Application No: K/2/22/HH
Site Address: 43 Golden Avenue East Preston BN16 1QX
Description of works: 2 storey front and rear extensions and alterations.

Planning Application No. K/2/22HH - 43 Golden Avenue

Proposed Front (West) Elevation

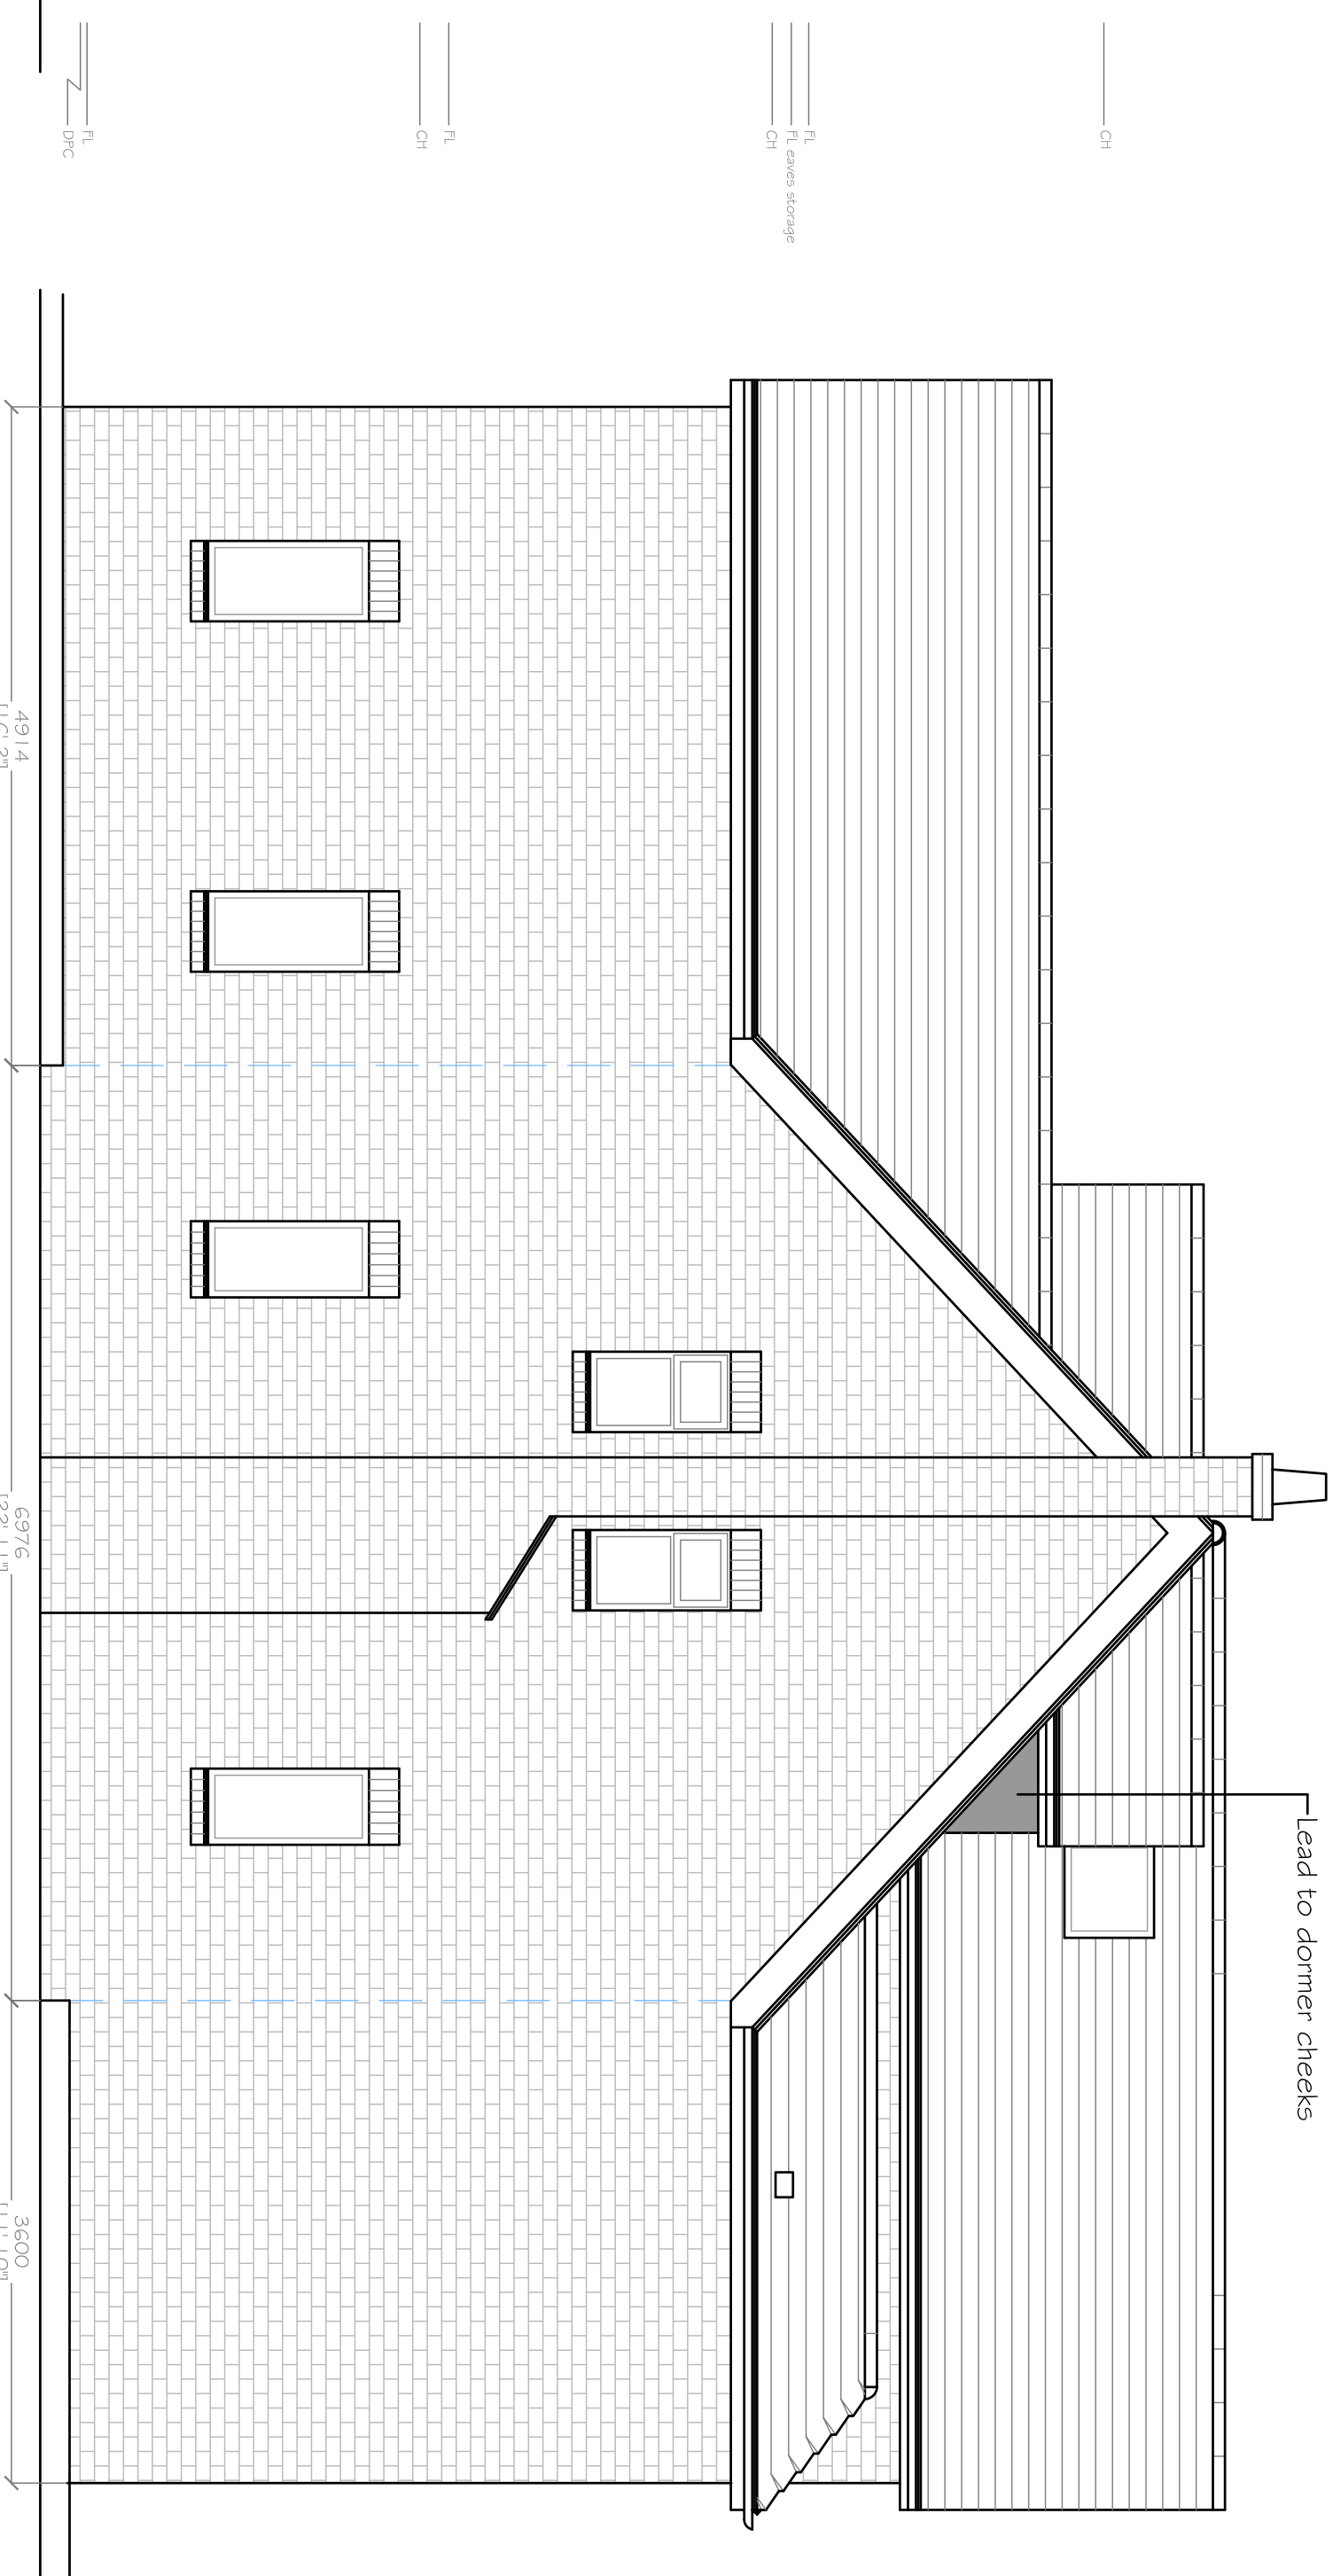
Further concerns that we have observed with the rear extension and the central roof accommodation is the depth and especially the height to the top of the central dormer styled room and roof. The consequence of

these proposals is that the windows on the first floor and the new balcony/window for the roof accommodation and to a lesser extent the roof dormer windows; they will all directly overlook into our garden and additionally will intrude on us, with the loss of our privacy.

The proposals will increase the overshadowing to our property including the loss of the natural daylight as a result of the new proposals, together with the added impact of the orientation of both properties.

The increase of overshadowing to the rear of our property will be seen as the sun moves around from east to west and passes behind the new extension and central dormer roof style roof extension, increasing the amount of shading into our garden.

Scale 1:500 @ A3
Proposed Block Plan

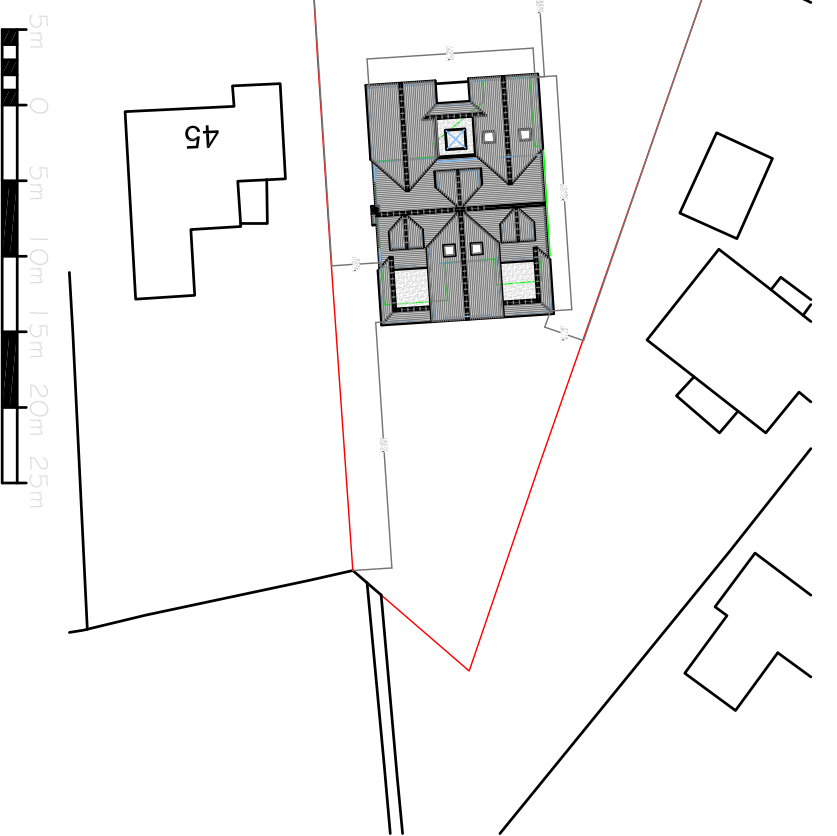
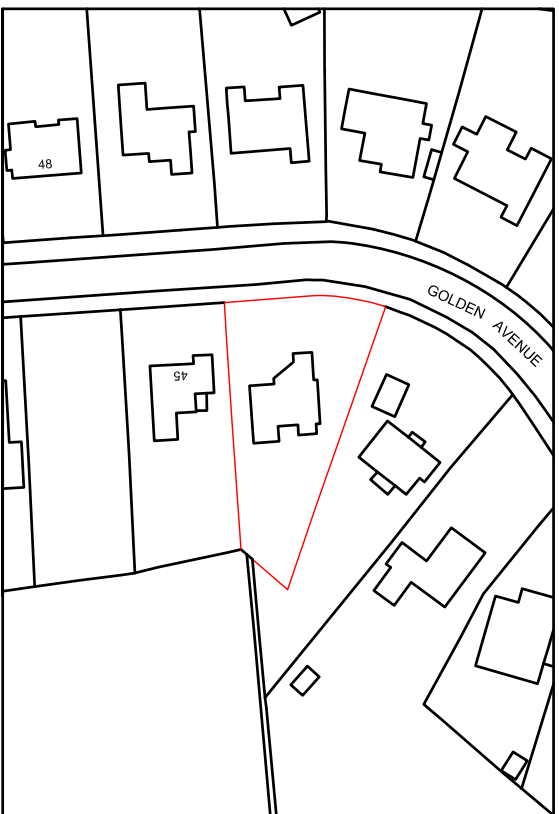
The drawings submitted for approval do not show any onsite parking for their vehicles. This is a requirement by West Kingston Residents Association Ltd for all residents on this estate to arrange for a suitable space for their vehicles.

Final observation from the drawings shows the proposed rear extension extending over the area restricted by the covenant for their property.
